From: Brenda Larsen
Sent: Tuesday, July 02, 2013 10:14 AM
To: Jeff Watson
Subject: RE: BL-13-00013 Hall

Re: Hall (BL-13-00013)

**BOUNDARY LINE ADJUSTMENT**  
PREPARED FOR  
GARY HALL  
A PORTION OF THE SOUTHEAST 1/4, SECTION 2  
TOWNSHIP 20 NORTH, RANGE 14 EAST, W.M.

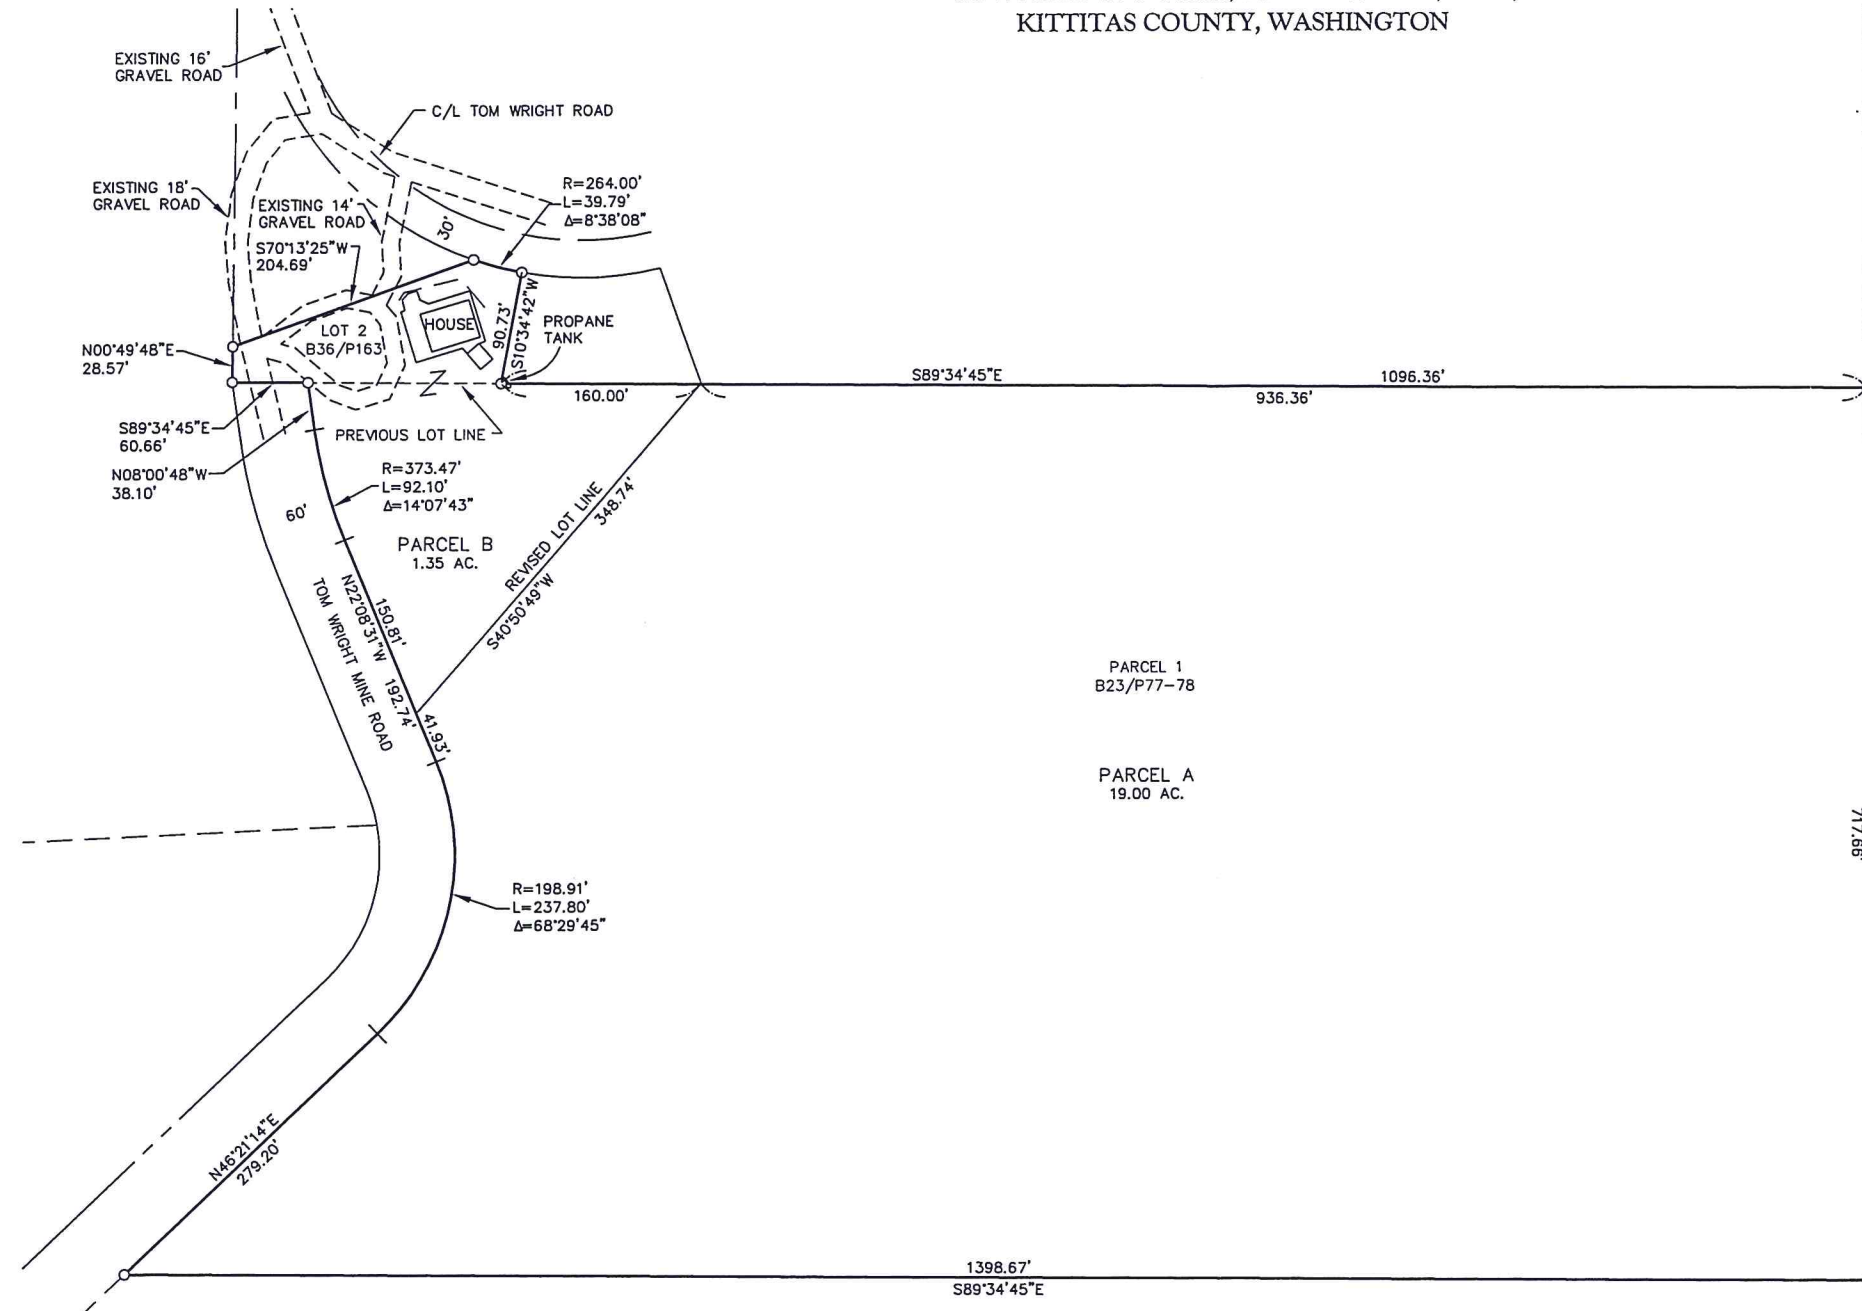
- Ensure that boundary line adjustments do not infringe upon existing structures, to include propane tanks, etc.
- Ensure adequate access for fire apparatus. Any driveways or access points created based off the new lot configurations shall comply with Kittitas County Code 20.02.030.
- All future development must comply with the International Fire Code.
